August 5, 2019

Re: MMC Congress Building | 22 Bramhall St | Level III Site Plan
Response to City Reviewer Comments re: Signage

Comments from City of Portland Urban Designer – Caitlin Cameron Dated December 13, 2018

Comments from City of Portland Traffic Consultant – Tom Errico, TY Lin Dated December 13, 2018

Existing Signage Location Plan

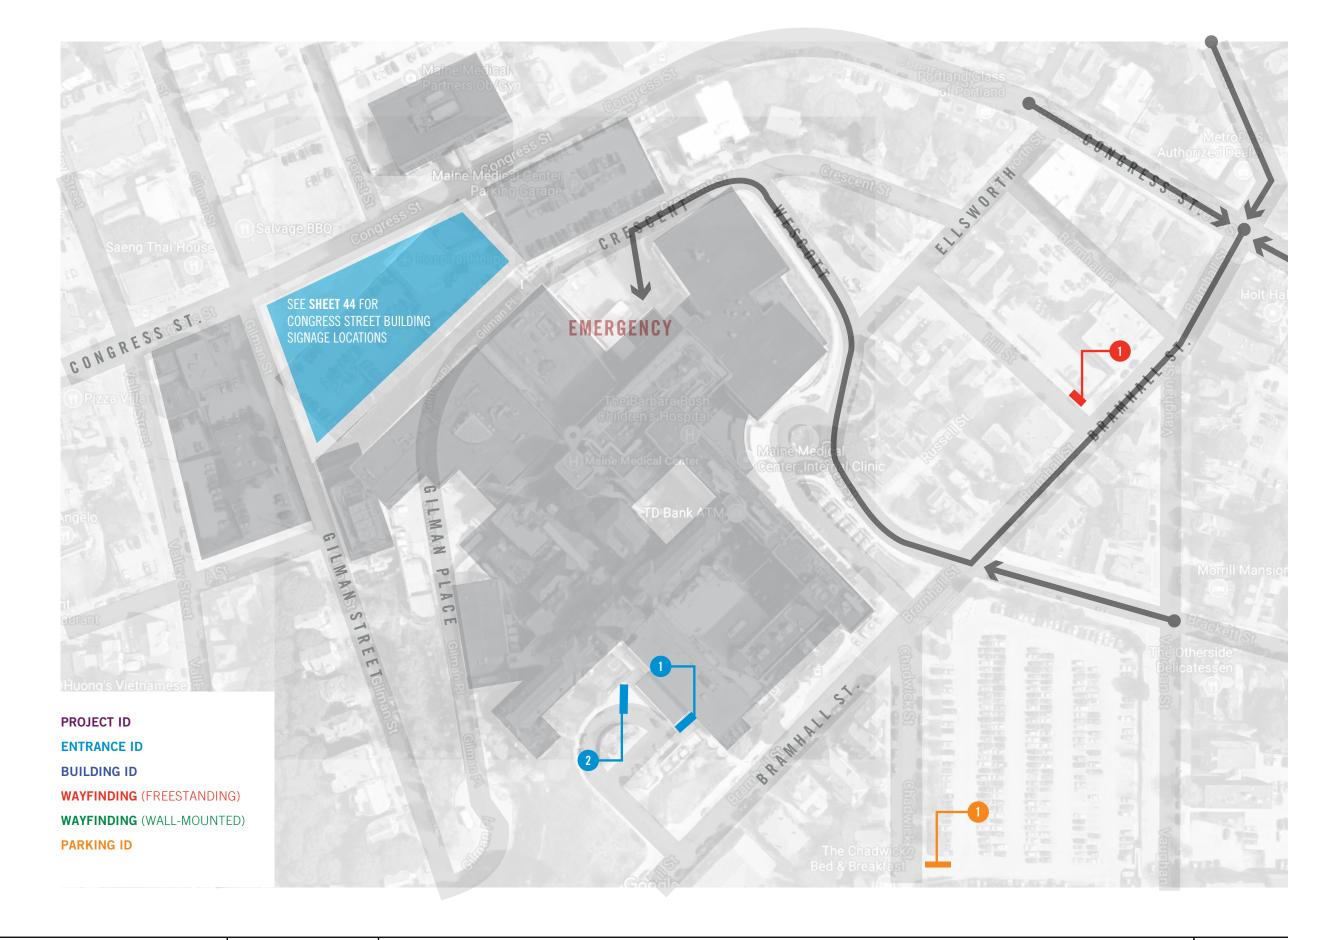
1. *Campus-wide Signage Plan: The draft campus-wide signage plan is included in this submission. Staff had the following comments:*
 - *Signs will not be permitted on properties not owned by MMC – remove the proposed sign on City property at Bramhall Square on page 13. Provide evidence of permission to install sign on property on Bramhall Street not owned by applicant.*

Response: MMC would like to work with the City on a signage solution that provides adequate wayfinding to the Emergency Department. MMC’s Emergency Department is the busiest in the State with over 66,000 patient visits in 2018. Providing adequate wayfinding to this essential element of public health and well-being is critical.

The revised signage plan includes placards that will attach to existing poles on Bramhall Square. These placards will supplement the existing Blue H signs.

The revised plan also includes replacing existing signage in the public right-of-way (signs 9 and 11 on page 11) that MMC believes are critical wayfinding elements for the Emergency Department.

Option 4: Blade Site Line Study at Entry

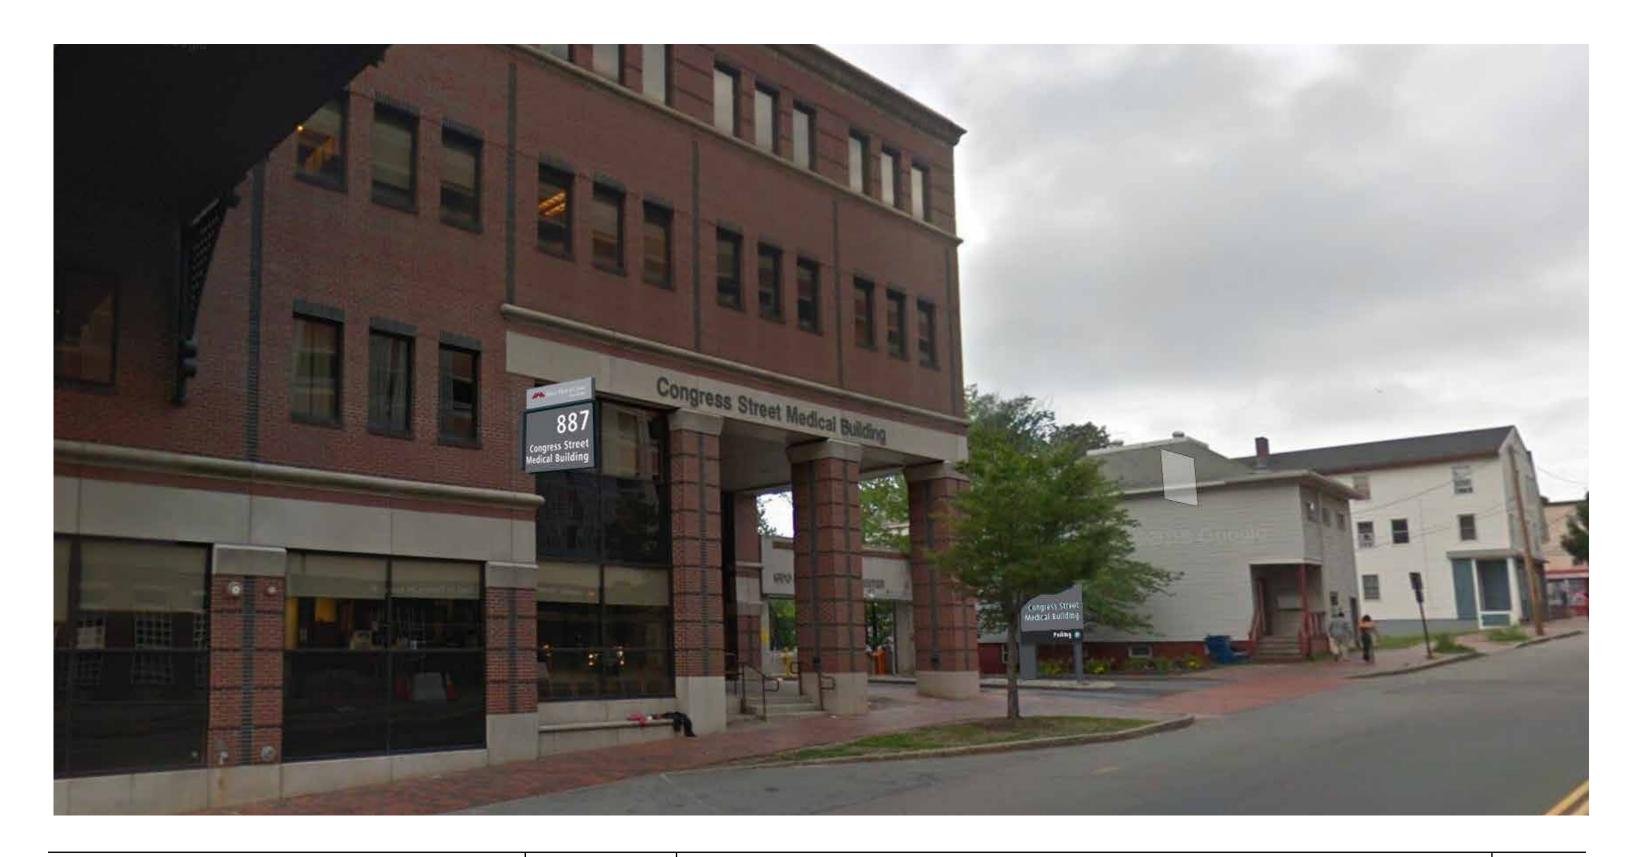
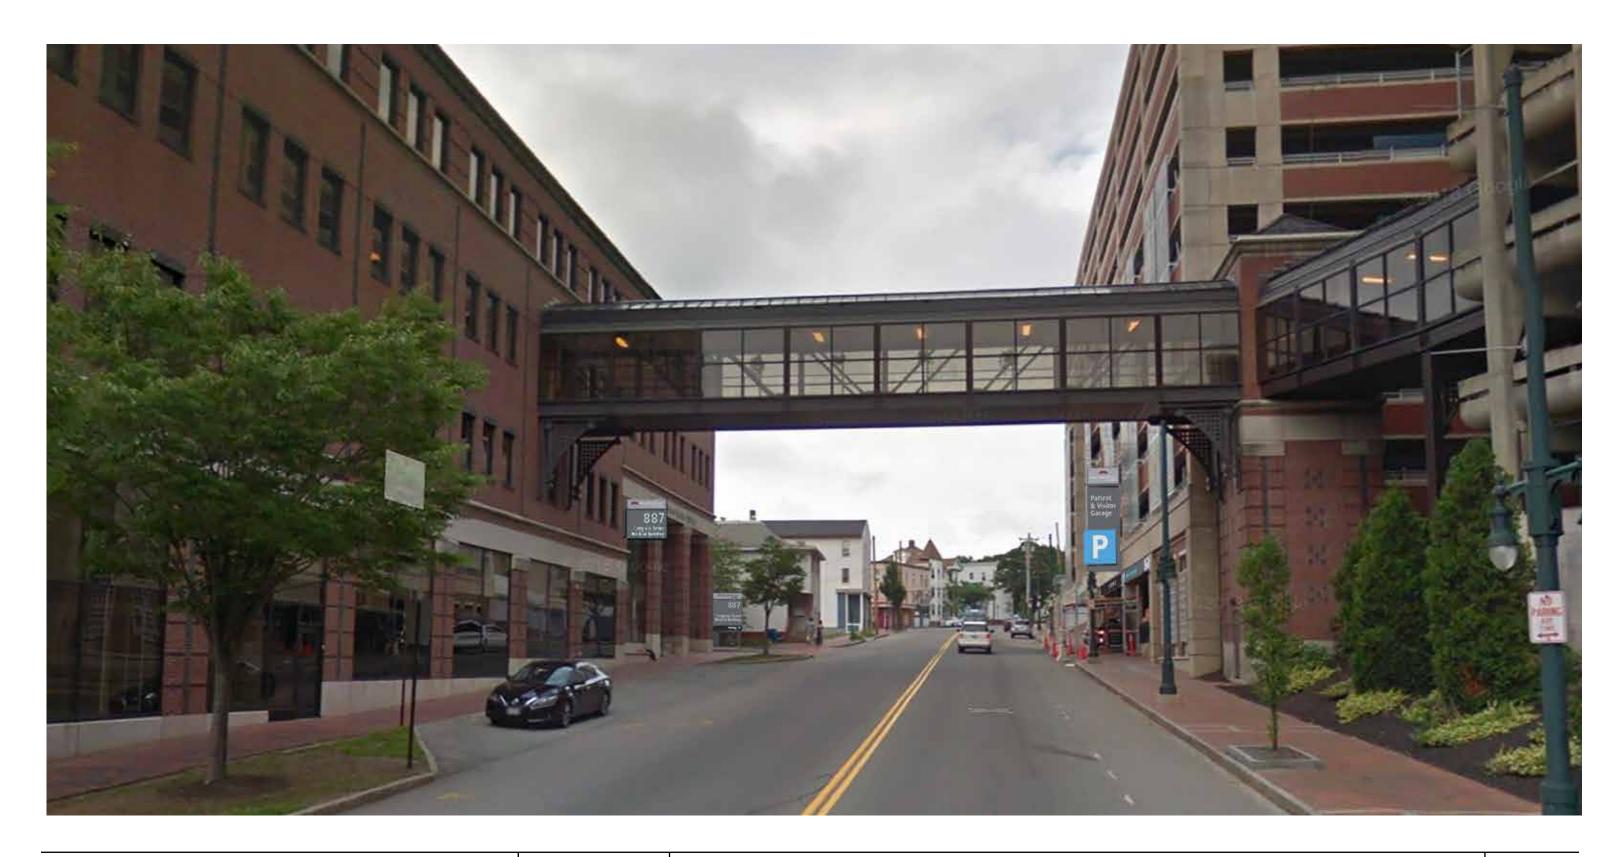
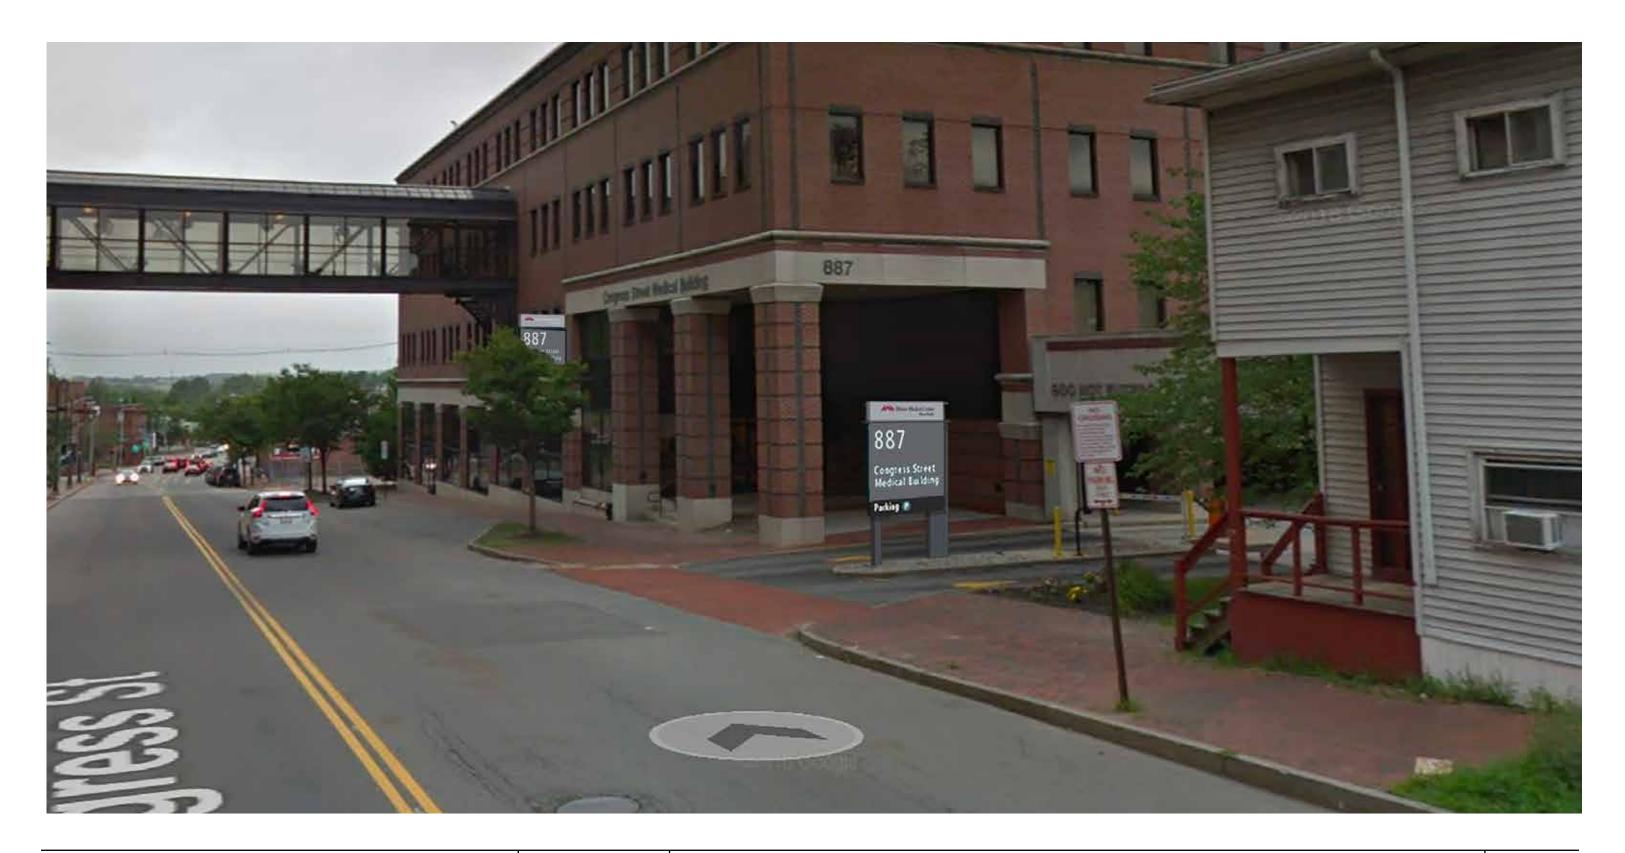
- ### 1. *The Applicant shall improve/enhance wayfinding to the existing MOB Parking Garage and the Visitor Garage. Advance directional signage should help to mitigate sudden stops that may have been a contributing factor in crashes. A signage plan shall be provided for review and approval by City staff.*

Response: In conversations with City Staff and consultants, MMC's traffic engineer identified a high-crash area for East-bound traffic on Congress St. near the MOB Parking Garage. Wayfinding for the MOB Parking Garage is an issue for east-bound traffic because the MOB blocks a portion of the sign coming from the East and not the West. As a result, MMC evaluated the following options to improve wayfinding for East-bound traffic to the MOB Parking Garage.

Option 4: Add a sign attached to the MOB building west of the pedestrian bridge crossing Congress Street. This option was eliminated due to concerns related to the proximity of the sign to the garage entrance.
